From: Ellie White [REDACTED]
Sent: Wednesday, October 27, 2021 3:10 PM
To: Maria Tomalova <Maria.Tomalova@arun.gov.uk>
Subject: Stakers Farm

Apologies I have been on leave so I have just picked up your voicemails. Unfortunately the voicemails aren't entirely clear. I have spoken with our architects who can very easily address all of Martyn's comments.

DRAWING TITLE
PROPOSED SITE LAYOUT

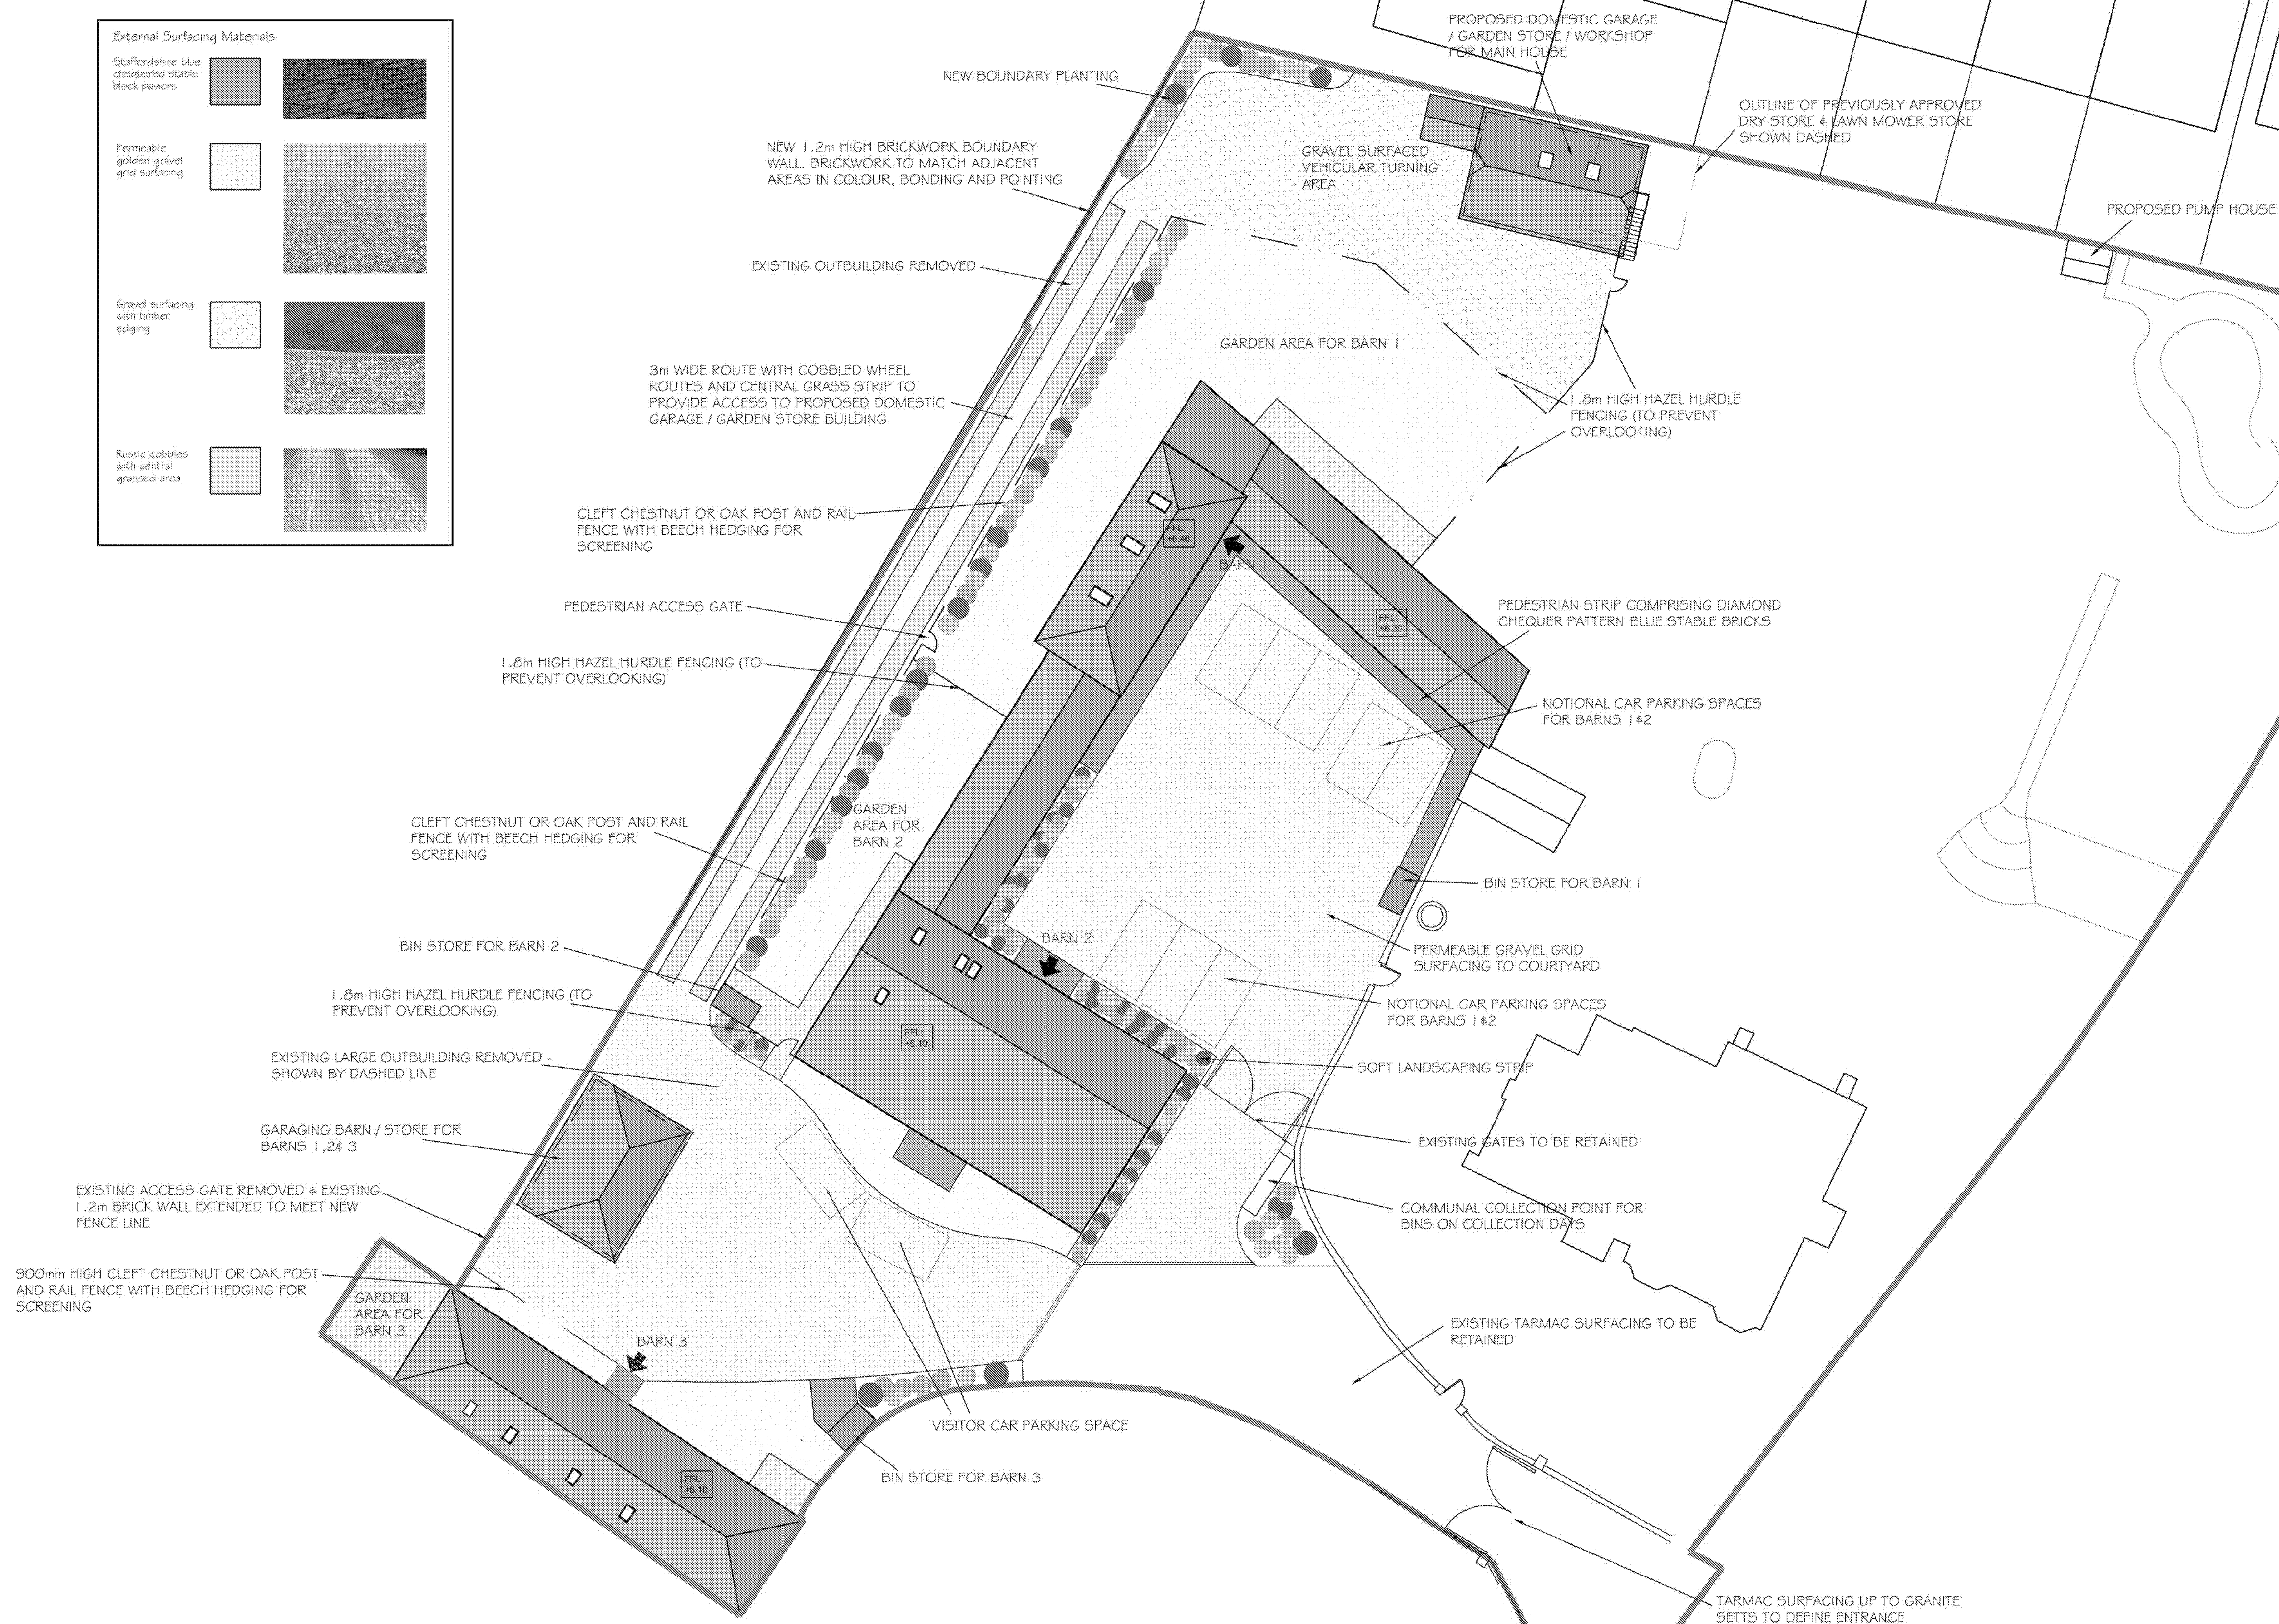
4. **Landscaping**. Boundary treatments have been noted on the proposed site layout plan. We would be pleased to provide additional information for any areas that require clarification.

In terms of the drive surface, we are just awaiting a response from our drainage consultants to check it fits with the drainage requirements/strategy. Would you like me to check the above points with Martyn so we can check that he is content?

DRAWING TITLE
PROPOSED ELEVATIONS

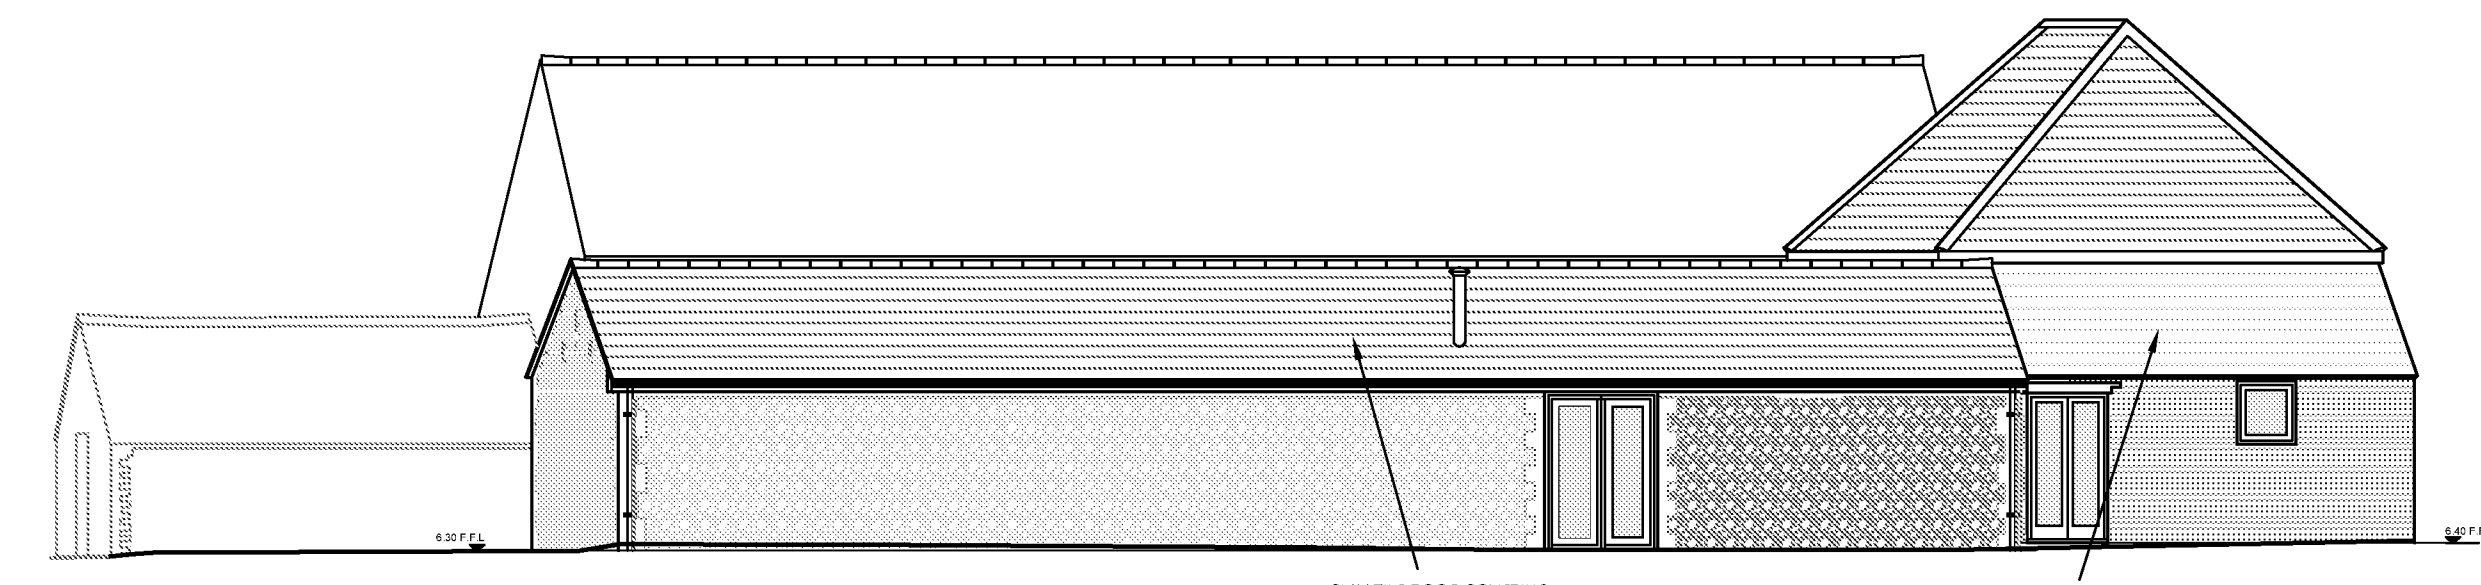
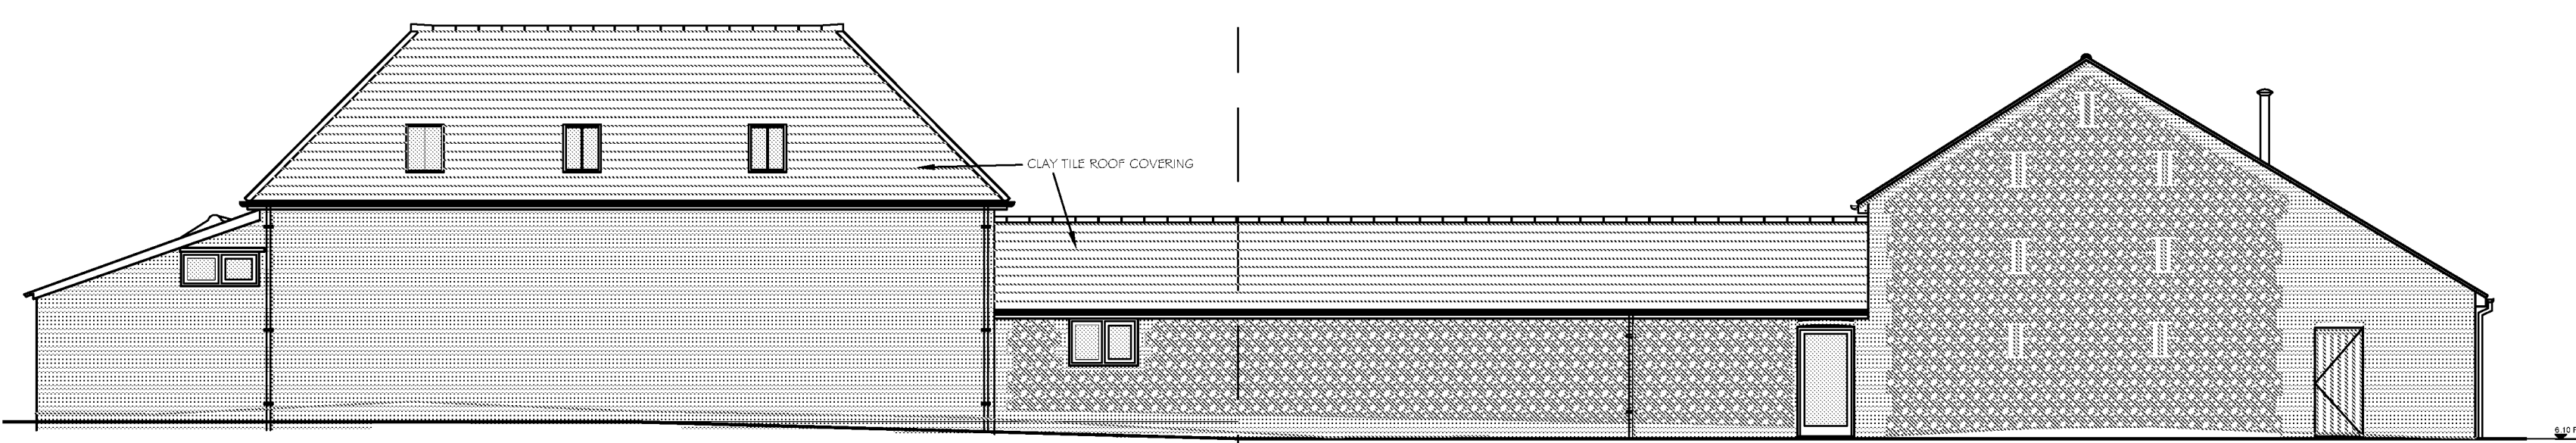
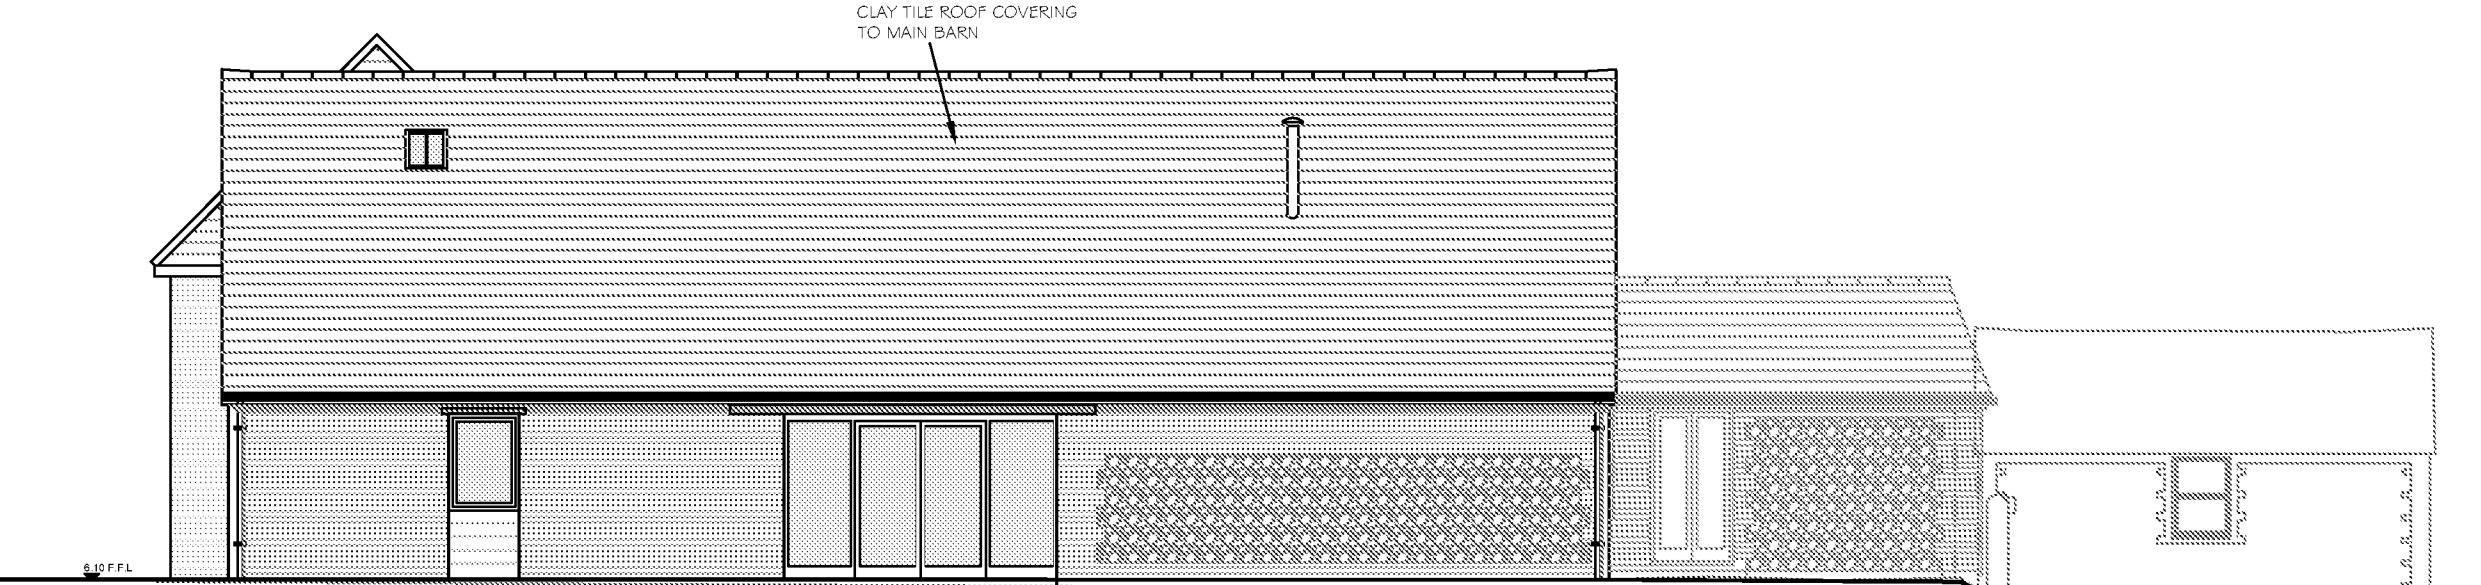
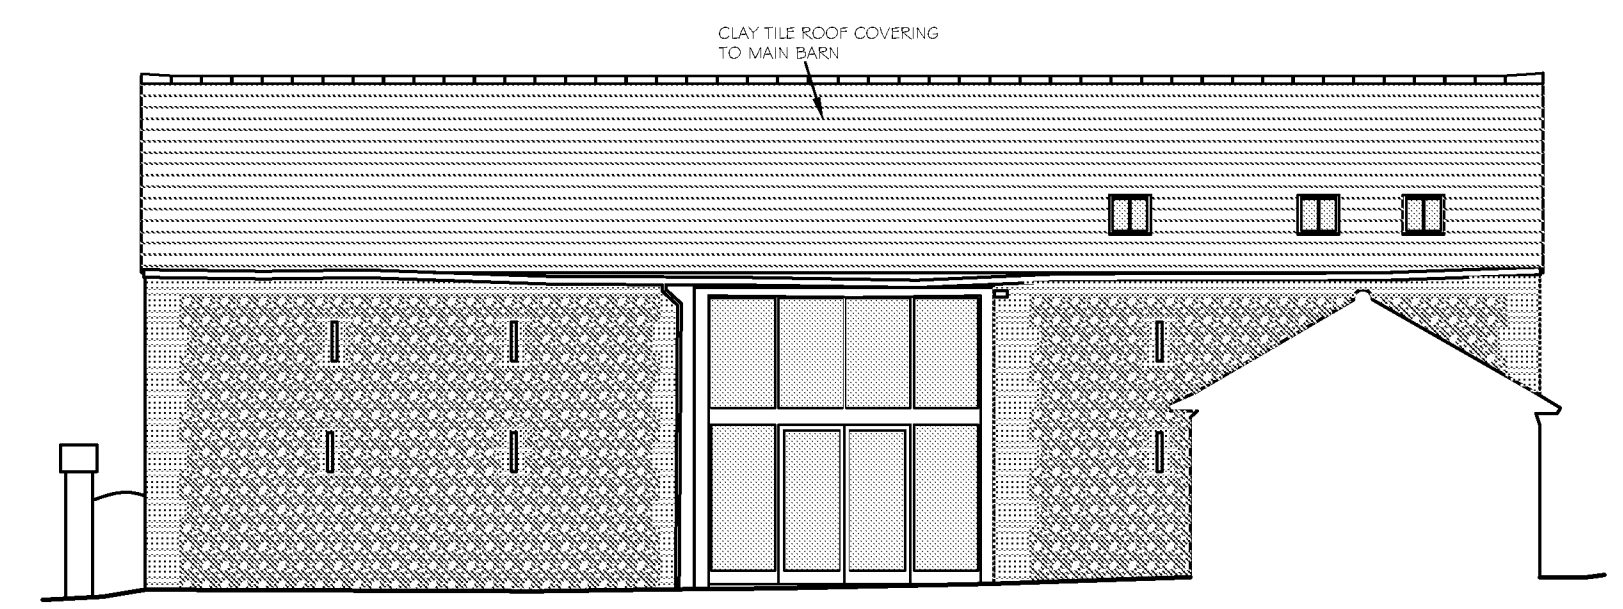
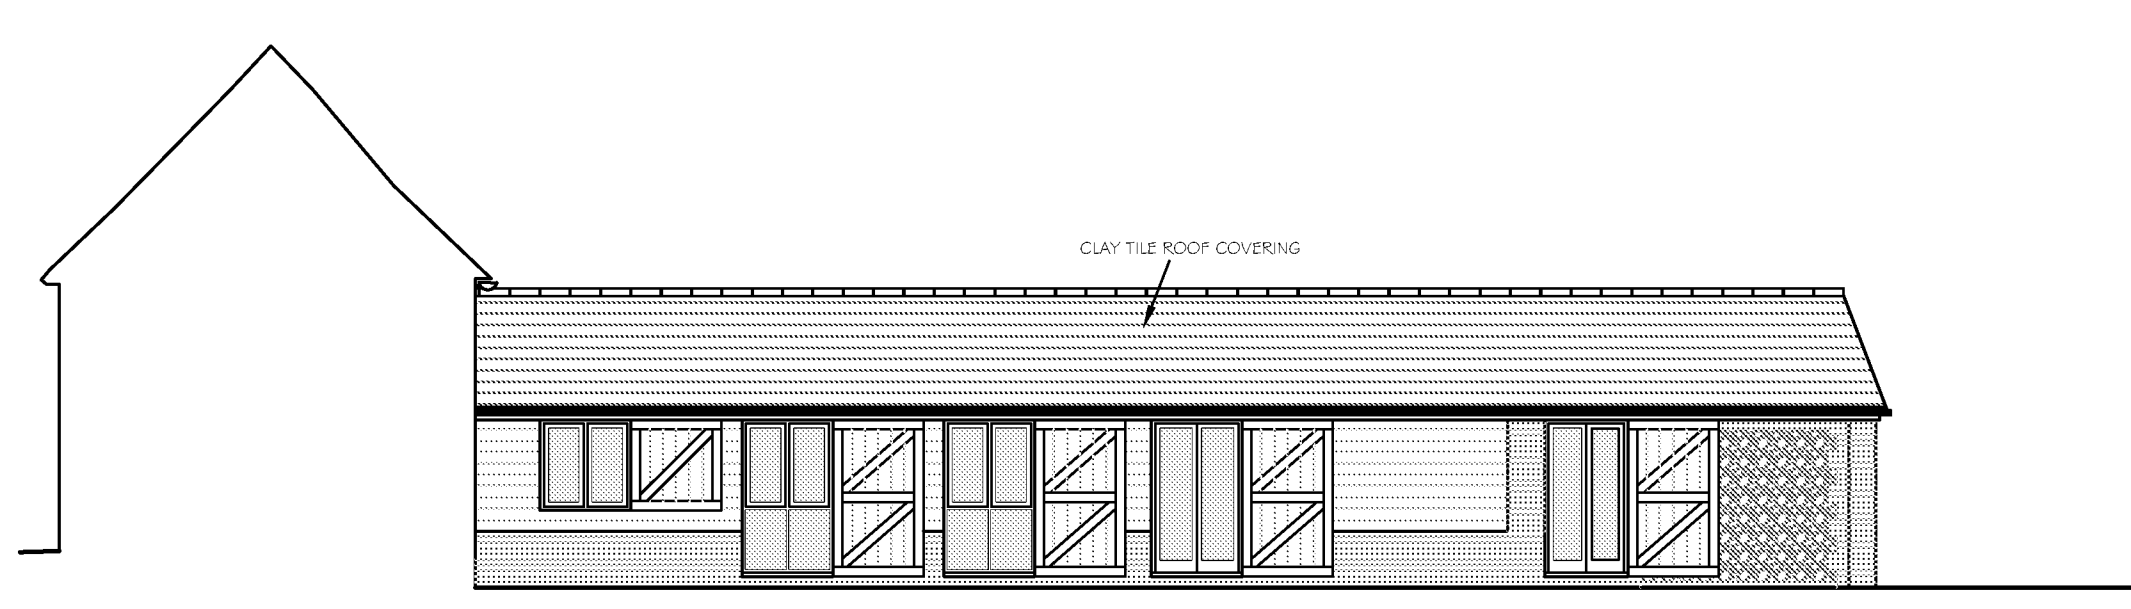
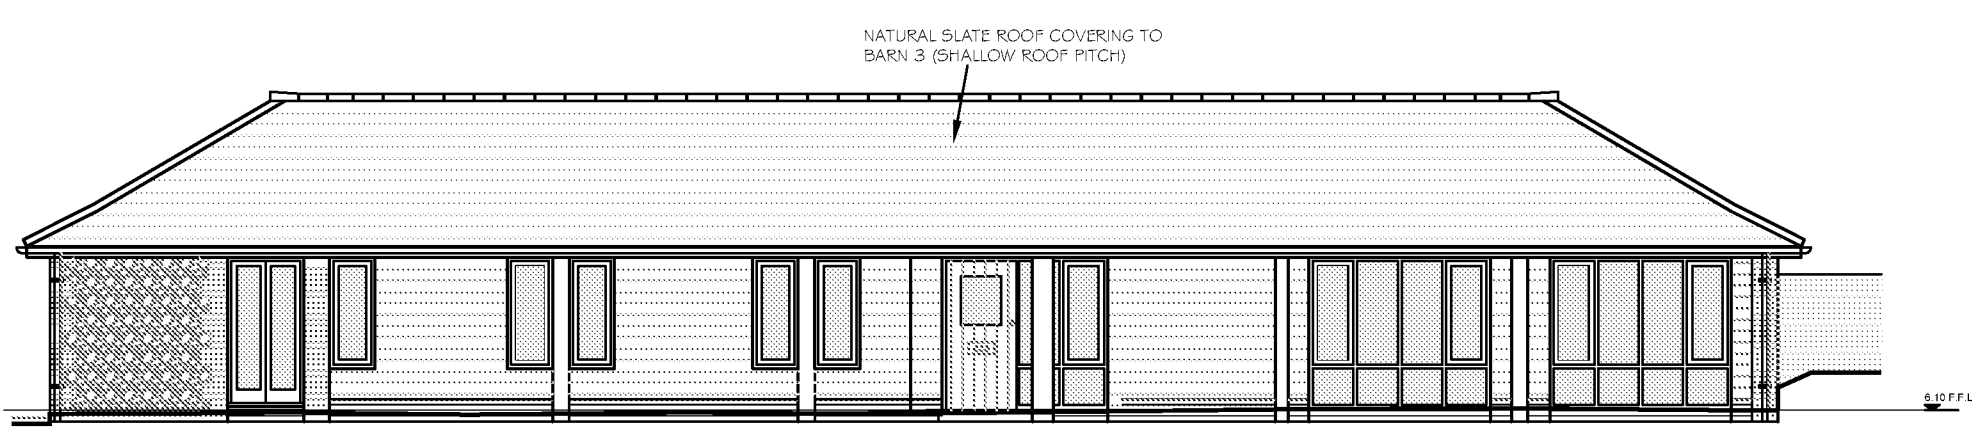
3. **Fenestration** – Windows and external doors generally have a vertical emphasis, which is appropriate for this type of traditional rural building. The broad style of fenestration is similar to that which originally obtained planning consent, and just a few minor changes have been introduced. Therefore, we would suggest that the acceptability of the general style of fenestration has already been established.
The large window to the south east elevation of Unit 2 (serving Bedroom 3) comprises a partial infill of an existing opening. The wall below this window would have horizontal timber boarding to differentiate it from the surrounding external materials in order to help define this area as an infilled large opening. Alternatively, full height glazing could potentially be provided instead.
The window to the utility room of Barn 2 is currently a bricked up door opening. This would be re-opened, and a window fitted above an area of wall which would be finished externally with horizontal timber boarding. This would help the history of the building to be interpreted, and would clearly be 'read' as an original door opening.

The windows to the south west elevation of Barn 1 follow the existing pattern of external doors to this area. The existing doors would simply be removed, and new full height windows or glazed doors fitted in their place. If required, full height external shutters could be fitted to provide a more rural appearance. However, the existing doors are now beyond repair and cannot be salvaged.
